State of Washington
DEPARTMENT OF FISH AND WILDLIFE

October 14, 2024

SUBJECT: WDFW COMMENTS ON SP-24-00031 MCINTOSH SHORT PLAT

McINTOSH SHORT PLAT PART OF SECTION 8, T. 18 N., R. 18 E., W.M. KITTITAS COUNTY, WASHINGTON

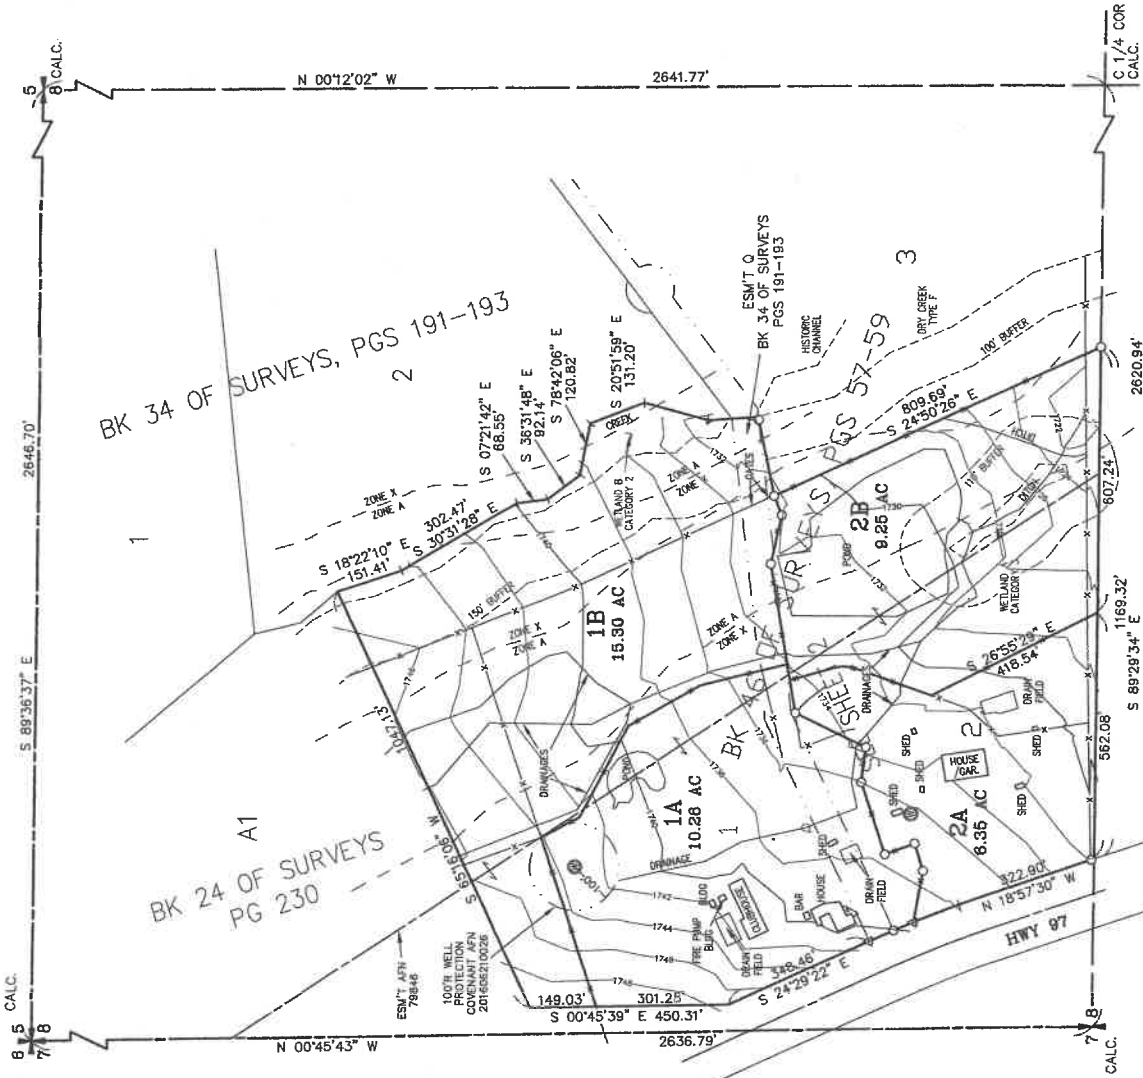
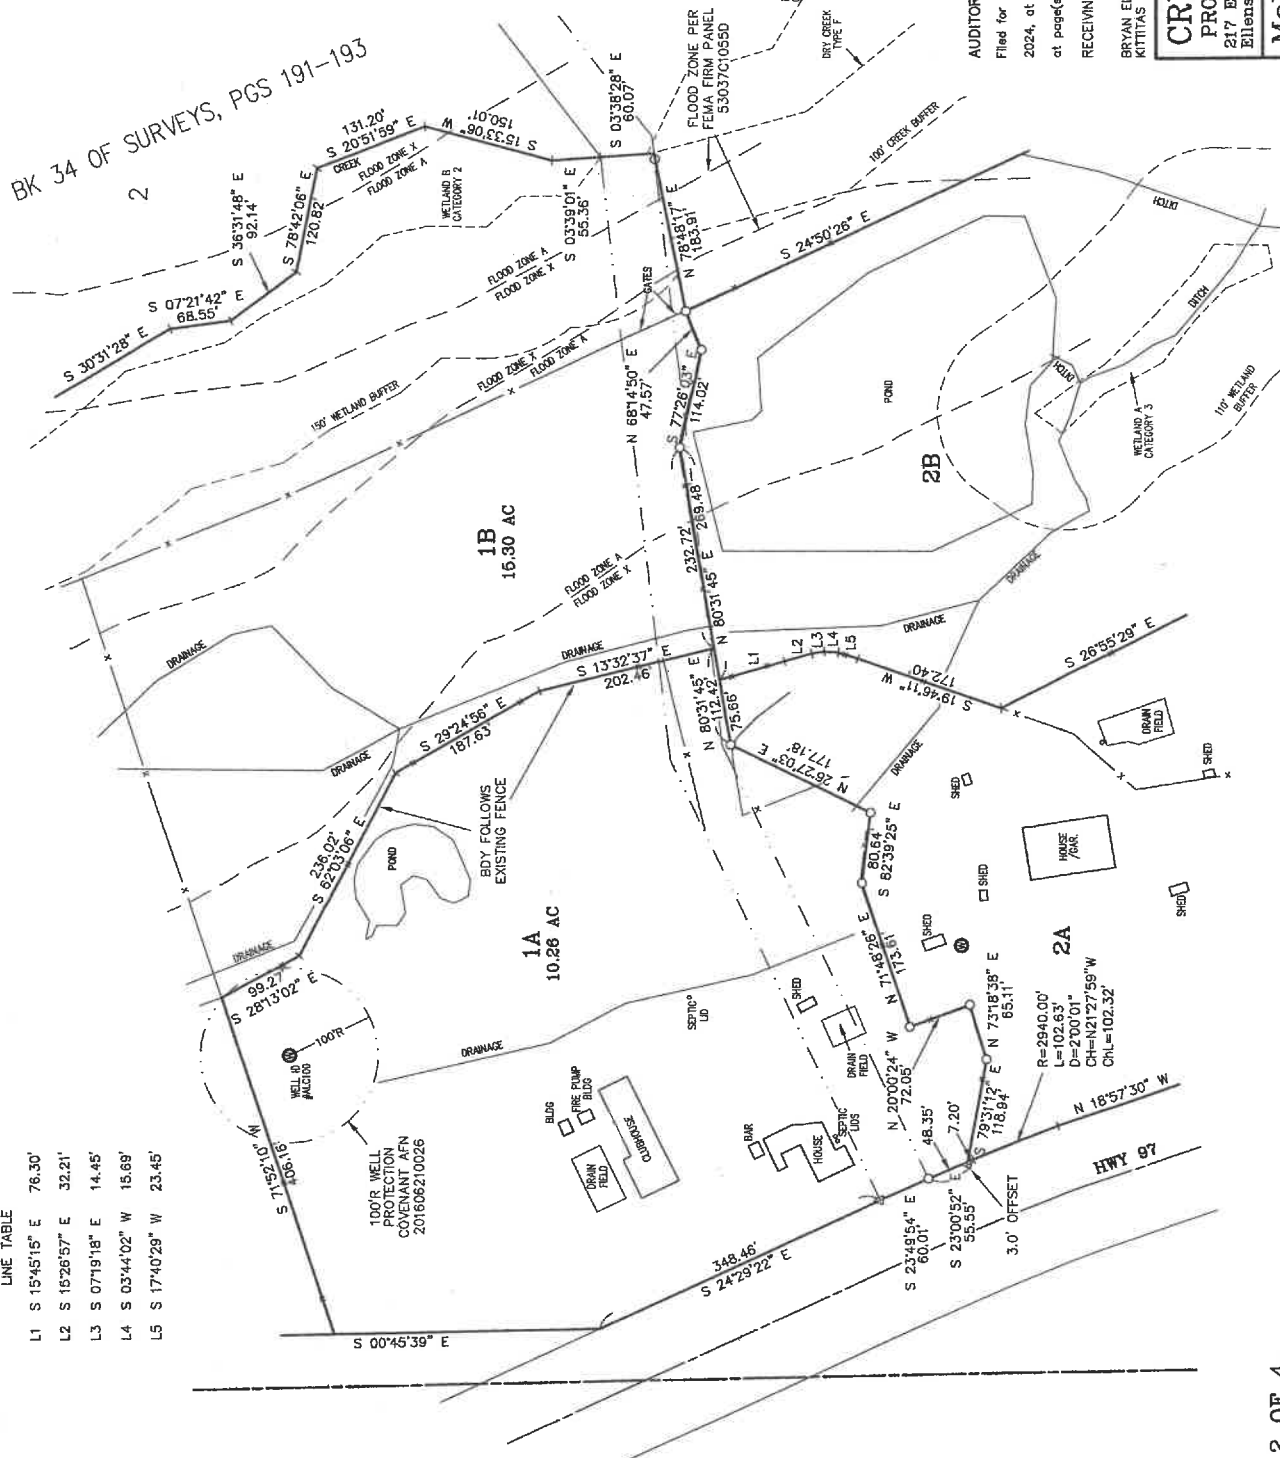
We understand that this proposal is a short plat, and no development actions are currently proposed. While no critical areas report is provided with the application materials, there are several critical areas present on the subject parcels, including Fish and Wildlife Habitat Conservation Areas (FWHCA), wetlands, frequently flooded areas, and Geological Hazardous Areas in the form of potential channel migration zones. Prior to new parcels being created as part of this project, the applicants should clearly demonstrate that they are not creating lots that will require variances and/or reasonable use exceptions from the critical areas requirements or other relevant sections of code when development is proposed.

Dry Creek runs near the easterly boundary of the project area. Dry Creek is a fish bearing tributary to the Yakima River. Multiple native fish species are present in Dry Creek, including salmon and steelhead. Relic channels throughout the project area are now regularly used for irrigation conveyance ditches, but during flood events, these irrigation ditches routinely convey flood waters as well and these events are not captured well by the FEMA maps. WDFW will be interested in any future grading and/or water crossing structures in and around Dry Creek and other channels in the project area and a Hydraulic Project Approval (HPA) may be required.

- Consider reducing the size of the lots around existing residences to provide a larger area for potential future building envelopes on the larger, new lots.

- Prior to approval of this application, complete a critical areas report that identifies all critical areas present within the project area and the required setbacks. Completing this

report and assessment will result in the identification of areas where development would be allowed without the need for variances or reasonable use exceptions.
